REQUEST

Proposed Zoning: MUDD-O (mixed-use development district, optional)
Approximately 20.12 acres bound by the east side of Old Providence Road and west side of Providence Road, north of River Oaks Lane.

The petition proposes a residential development containing up to 745 dwelling units. The site currently contains two single-family homes but is otherwise vacant and mostly wooded.

Staff does not recommend approval of this petition in current form.

RZ2-00

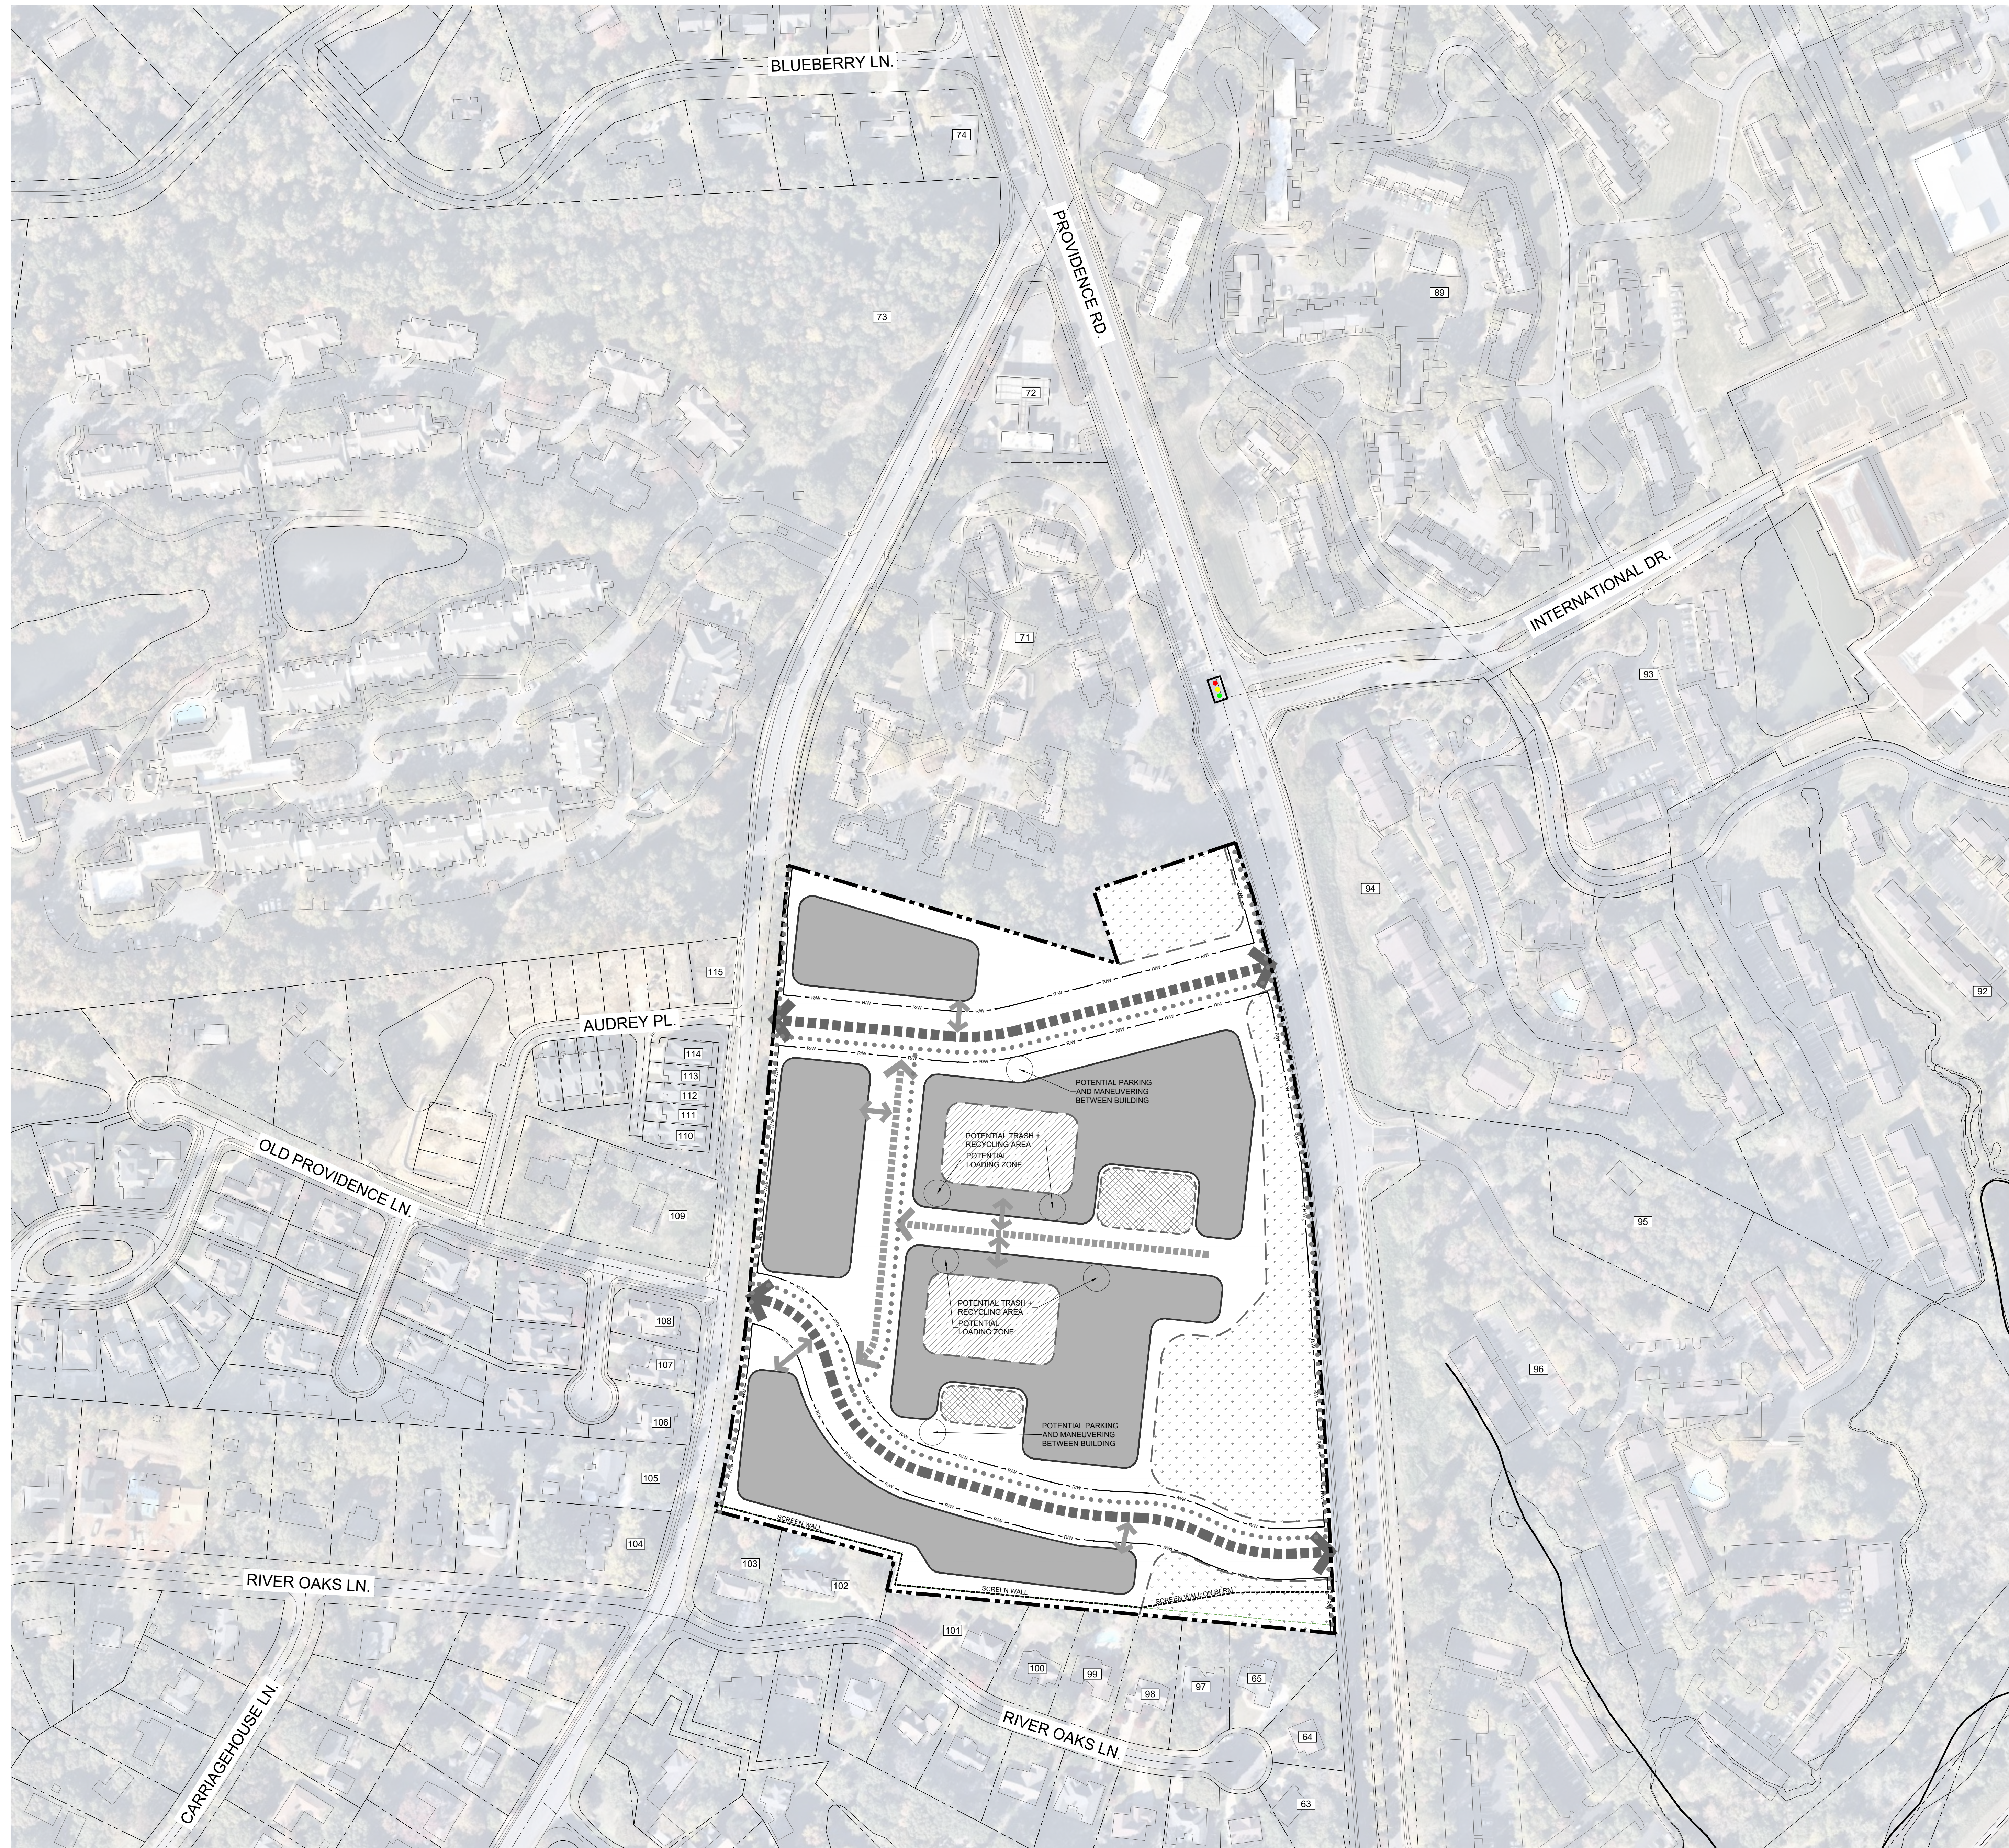
- The proposed site plan contains 4 Development Areas: A, B, C, D. The site plan specified that Areas A, C, and D are limited to single-family attached and detached dwellings unit. But does not outline the maximum development potential for each individual area, such as the proposed number of units. The plan does not specify if Development Area B may contain single-family attached and detached units or if it is limited to multi-family. The plan should clearly outline the maximum development potential for each Development Area.

4. Coordinate and provide cross-access connection between this the site and the Horizon Properties site to the north, petition 2023-023.
5. Reduce maximum building height in for multi-family buildings to 65 feet. Reduce maximum height of single-family attached and detached buildings to 48 feet.
6. Clearly state on the site plan the maximum development potential including maximum number of each dwelling unit type for all 4 Development Areas.
7. Commit to providing a 12-foot multi-use path and 8-foot planting strip along the Horizon Properties development, petition 2023-023, to the crosswalk at International Drive. To ensure access to the Levine Properties development, petition 2023-038, and the McAlpine Creek Greenway.
